Your ref: SSD-8903-MOD 4

Subject: EHG comments on Environmental Assessment for the Modification Application - Ivanhoe Estate, Macquarie Park - Stage 1 (Midtown) - SSD-8903 MOD 4

Subject: EHG comments on the Modification Application to Ivanhoe Estate (Midtown), Macquarie Park - Stage 1 - SSD-8903 MOD 4

Figure 3 *Trees subject to this application (outlined)*

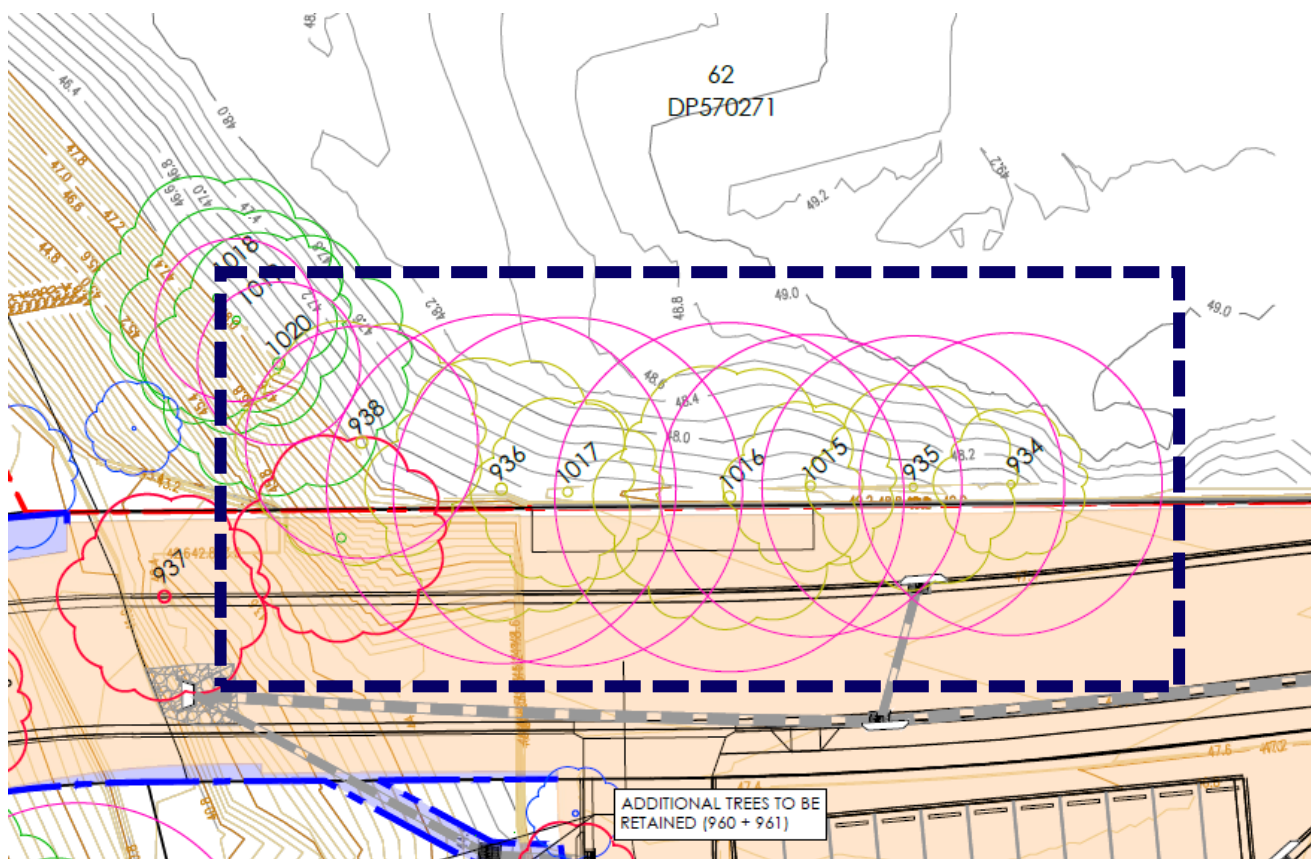
The MOD 4 proposal seeks to remove seven trees (934, 935, 936, 938, 1015, 1016 and 1017) that were approved for retention. Due to further investigations into the structure of a crib wall and the location of structural roots, these trees are not able to be retained as part of site preparation works and the delivery of the road connection to Lyonpark Road undertaken as Stage 1 of the Ivanhoe Estate (Midtown) redevelopment.

Section 6 of the Modification Application report notes a few of the subject trees were considered to have high retention value under the original Arboricultural Impact Assessment (AIA). The AIS indicates this means “these trees are considered important and should be retained and protected” (see Section 1.9 of the AIA). EHG notes the high retention value trees are three *Ficus macrocarpa* trees (936, 1016, 1017). The RtS needs to provide details on why the trees are considered to have high retention value and whether any of the seven trees to be removed contain nests, dreys, hollows etc.

EHG recommends pre-clearance fauna surveys are undertaken for the removal of the seven trees and a qualified ecologist relocates any resident native fauna to an appropriate nearby location. If any hollow dependent native fauna are found using existing hollows, compensatory tree hollows should be provided prior to removing the hollows and prior to the release of the hollow dependent fauna unless the removed tree hollows can be relocated and installed on the same day they are removed.

As the seven trees were initially approved to be retained, EHG recommends the trees proposed to be removed are replaced at a ratio greater than 1:1 (for trees not covered by a biodiversity offset strategy) to mitigate the urban heat island effect and to enhance tree canopy and habitat on the site. The loss of existing trees and the benefits that they provide can take years for a juvenile tree to grow and replace.
